26 August 2021

John Hunter Health and Innovation Precinct SSD – 9351535

Response to Public and Agency Submissions

## PROPOSED SITE PLAN - NORTH ROAD EAST PHASE

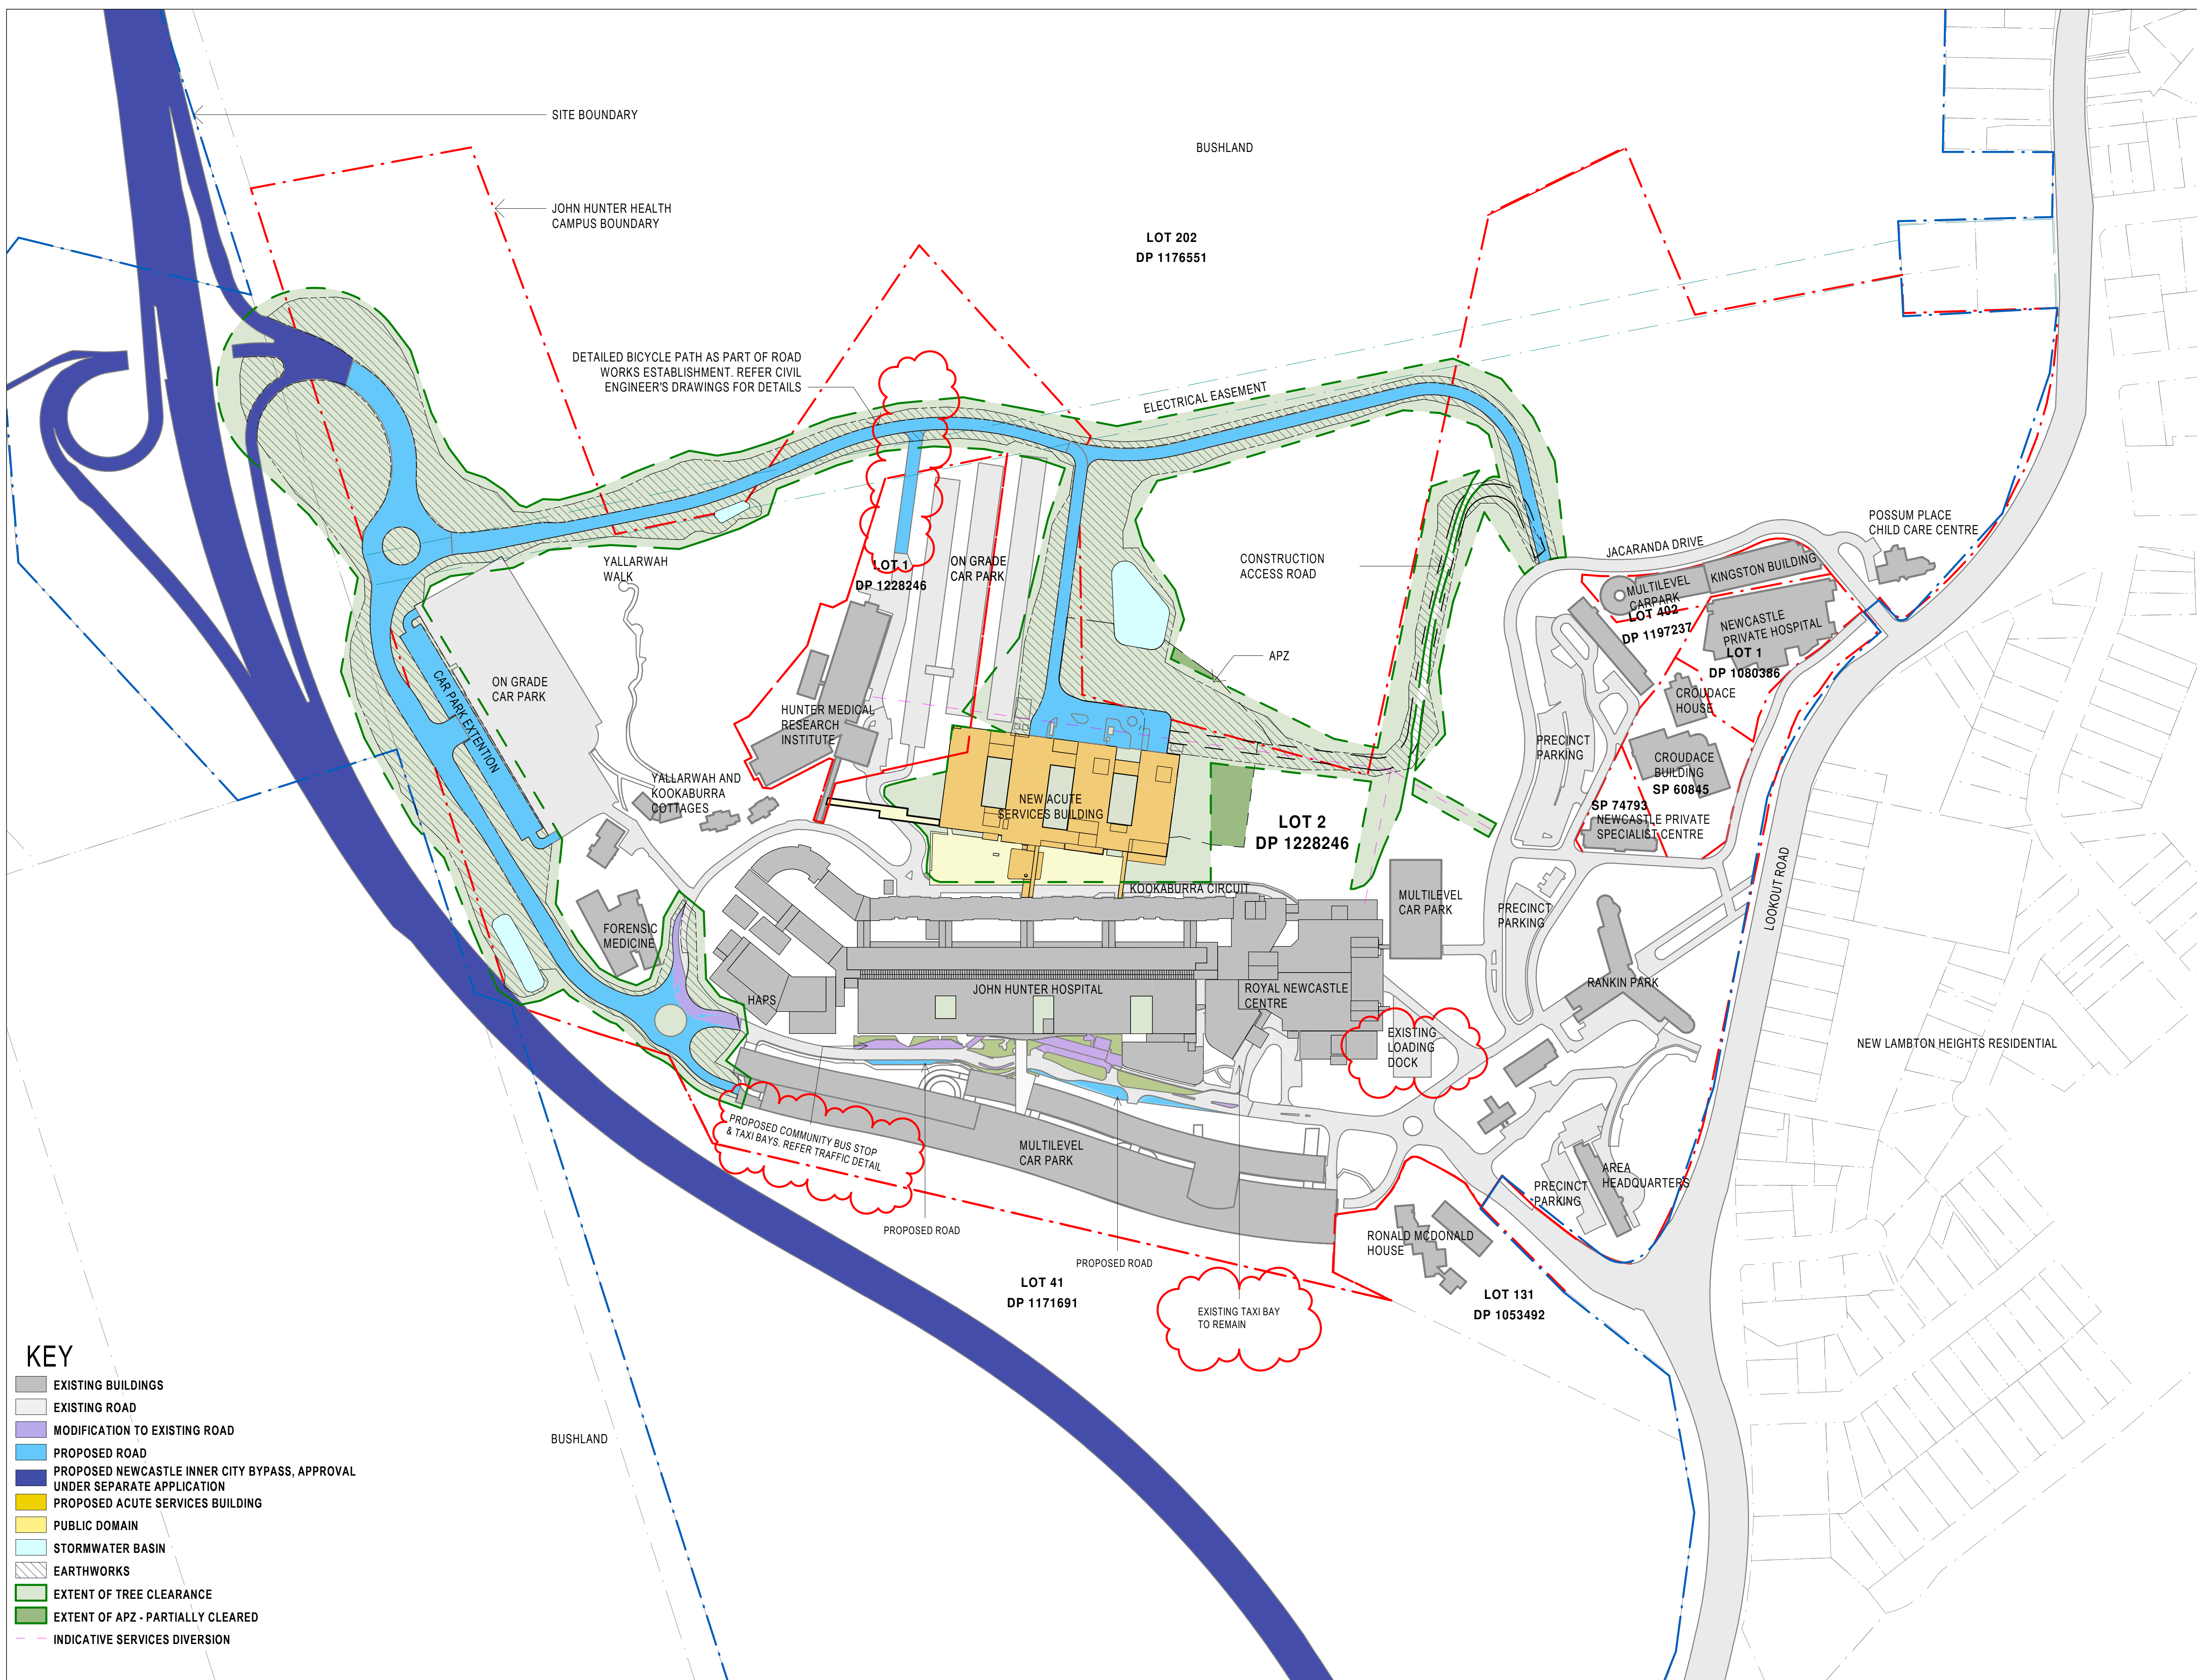
<p>5. Update the architectural plans to include:</p> <ul style="list-style-type: none"> - existing loading docks/logistics area to be retained. 	Additional details provided at Appendix B - Refer drawings AR_C0-A22 NL-X0 & AR_C0-A22 NL-X1
<ul style="list-style-type: none"> - dimensions on the elevations/sections for the new hospital building and any new structures/link bridge/canopy. 	Additional details provided at Appendix B - Refer drawings AR_C0-C10 XX-X0, AR_C0-C10 XX-X1, AR_C0-C10 XX-X2, AR_C0-D10 XX-X0, AR_C0-D10 XX-X1
The City of Newcastle Council	
<p>1. Aboriginal Cultural heritage</p> <p>A search of the Aboriginal Heritage Information Management System found four known Aboriginal sites within a 200m radius. In addition, much of the proposed works are located within undisturbed areas. An Aboriginal Cultural Heritage Assessment Report (ACHAR) was undertaken and assessed the site as having low archaeological potential. The ACHAR provided includes a number of management recommendations which are recommended for inclusion as conditions of consent, should the development be approved.</p>	Noted. The ACHAR recommendations have been adopted for inclusion in the consent, by the project.
